TECHNICAL NOTE

Job Name: The Eagle at Barrow Hotel, Clitheroe
Job No: 333100728
Note No: TN01
Date: 18th August 2025
Prepared By: Jessica Harding
Approved By: Brian Laird
Subject: **Eagle at Barrow Hotel, Clitheroe**
Proposal: **Proposed Hotel development comprising two-storey building (use Class C1) with associated parking and landscaping, bin store, air conditioning units and new pedestrian access.**
Land at The Eagle at Barrow Hotel, Clitheroe Road, Clitheroe, BB7 9AQ
Planning Application Ref: 3/2025/0100

Drawing no.	FB ref.	revision
2023/91/02	2023/91	G

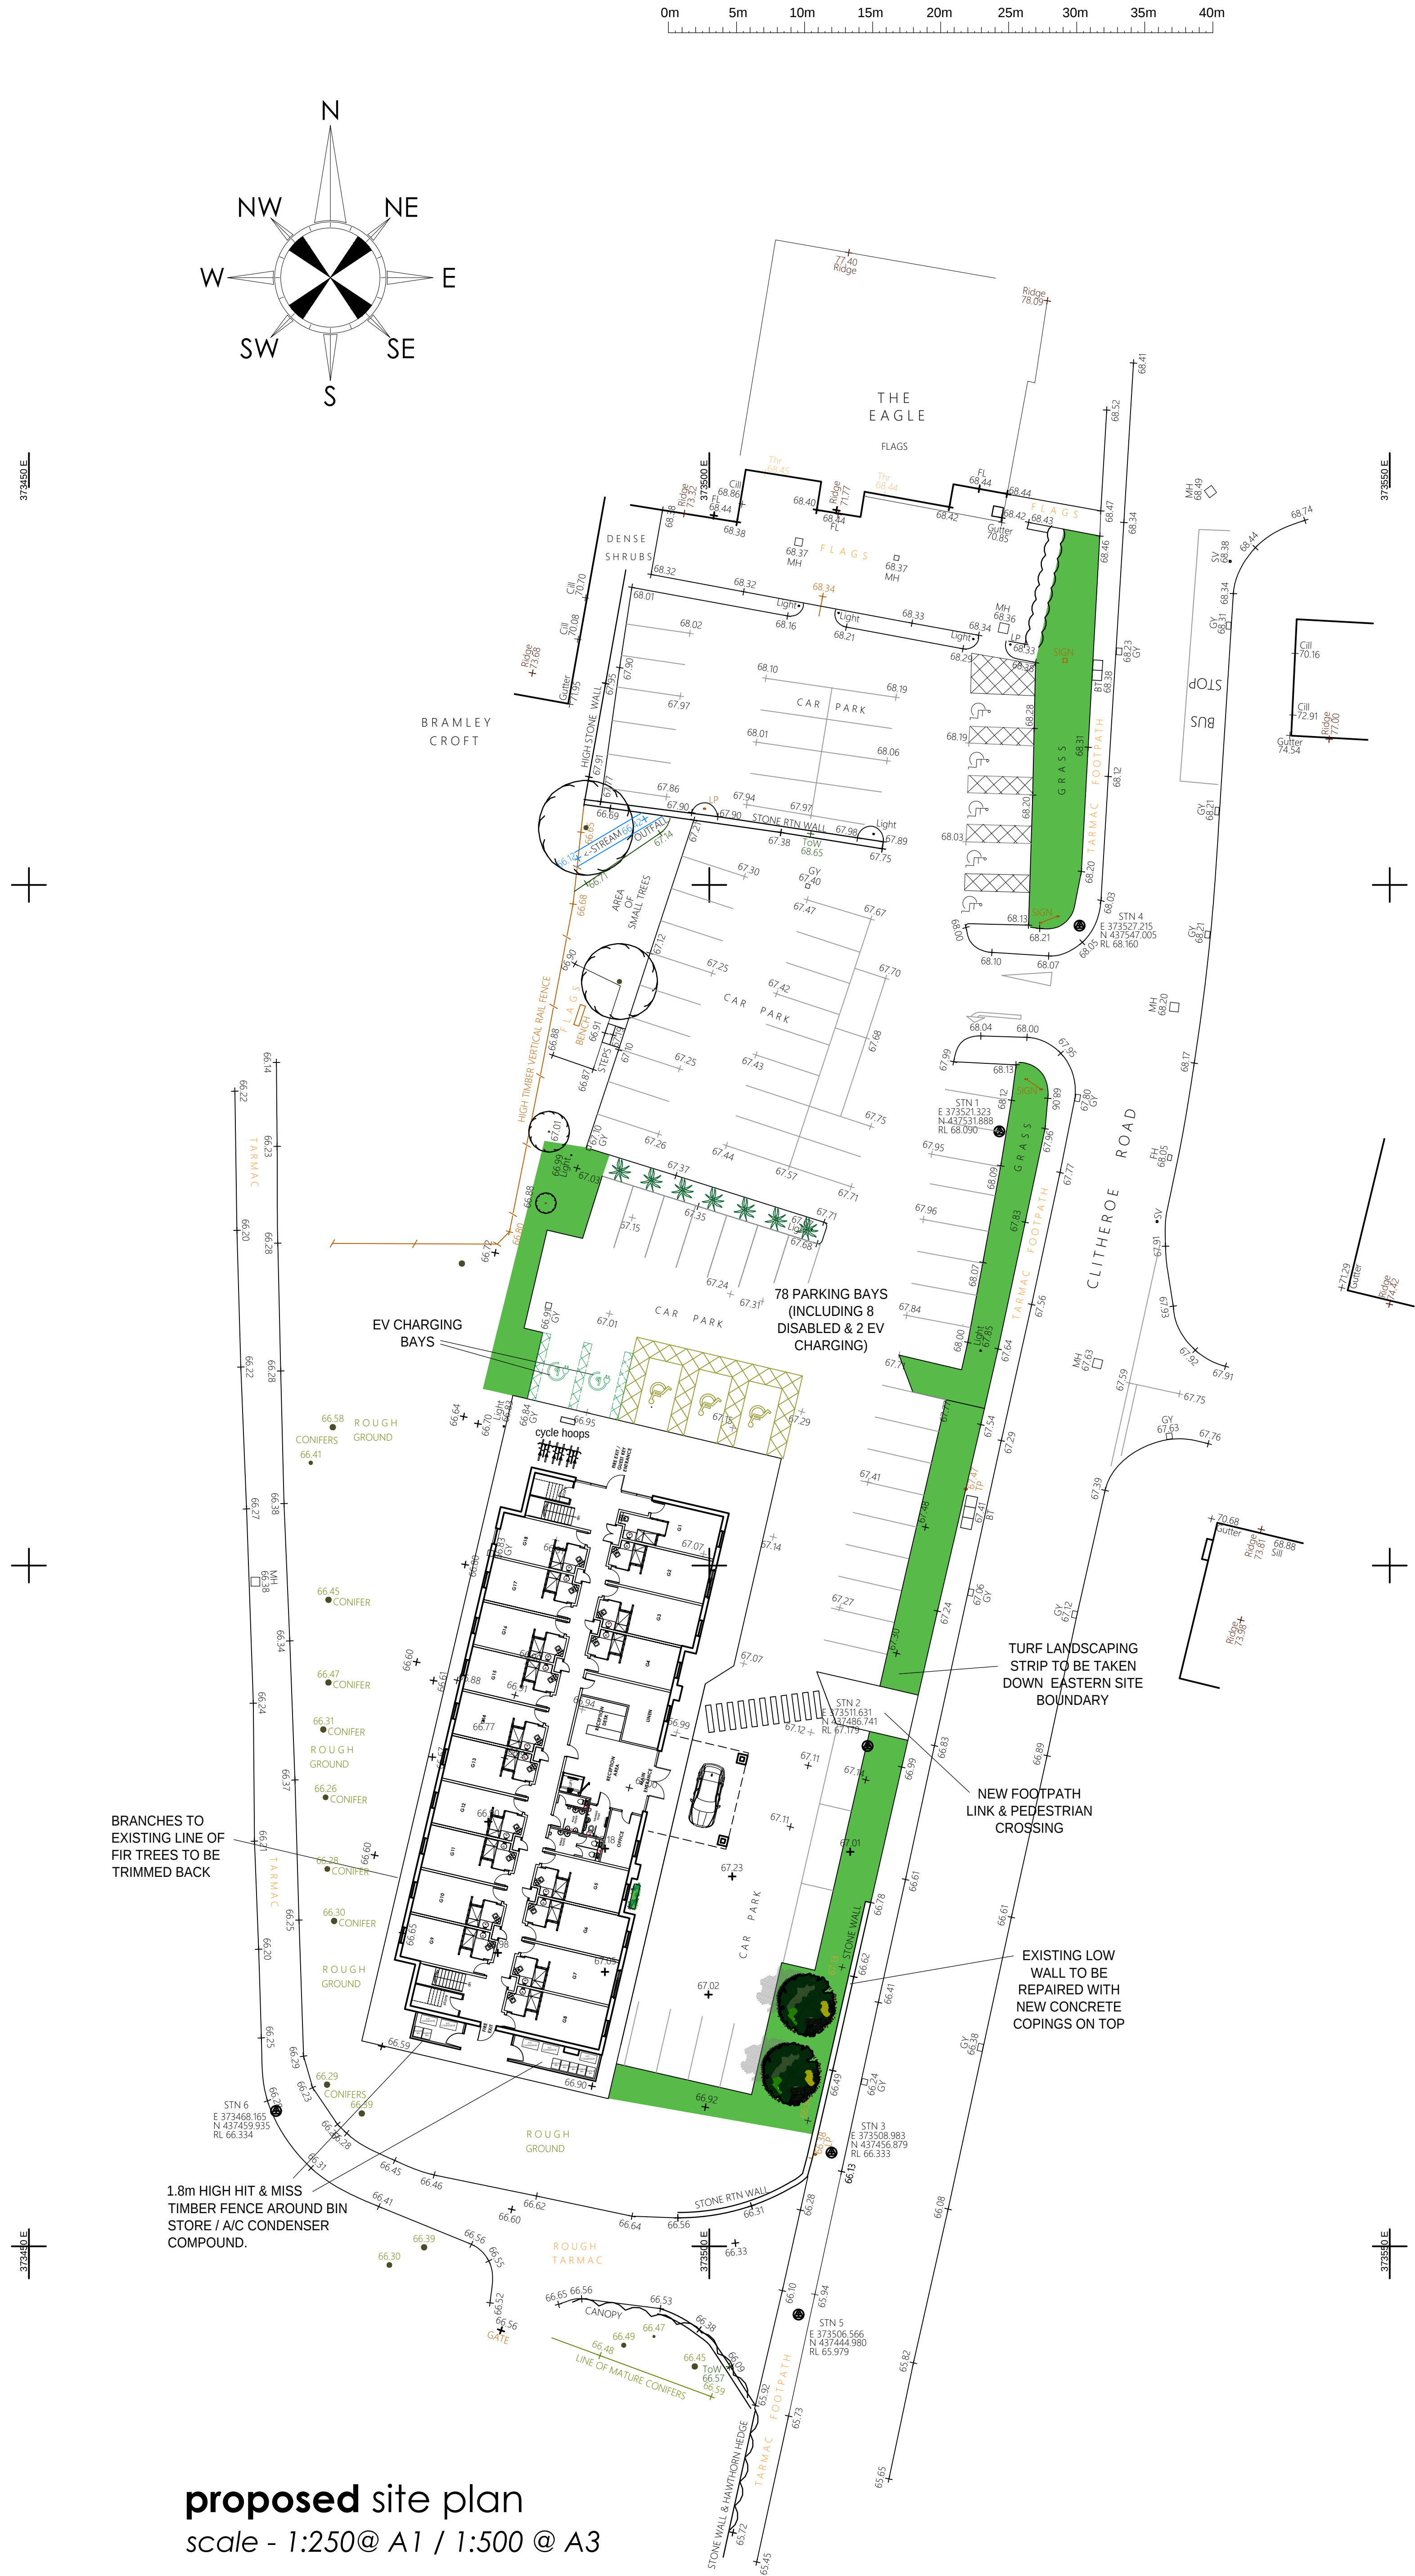
The submitted documents and plans including 'Proposed site plan 2023/91/02-Rev G, Stantec Transport Statement dated February 2025 have been reviewed and the following comments are made.

We would request that tactile paving is added to the site access dropped crossing points.

There are 8 disabled parking spaces and 2 electric vehicle charging spaces proposed, these should be 10% of the overall provision. There are 6 bicycle parking spaces (3 sheffield stands) proposed and these stands will need to be covered and secure and

increased to 10% of the car parking provision. Motorcycle parking is required at 4% of the car parking provision.

- 5.1. LCC has requested tactile paving to be placed at the existing access dropped crossing.
- 5.2. The Applicant accepts the request for tactile paving at the existing access. The provision of the tactile paving shall be subject to a 278 agreement.

- Provide a dropped kerb, appropriate lining and signage at the proposed pedestrian access on Clitheroe Road; and
 - Provide tactile paving at the existing site access dropped crossing.
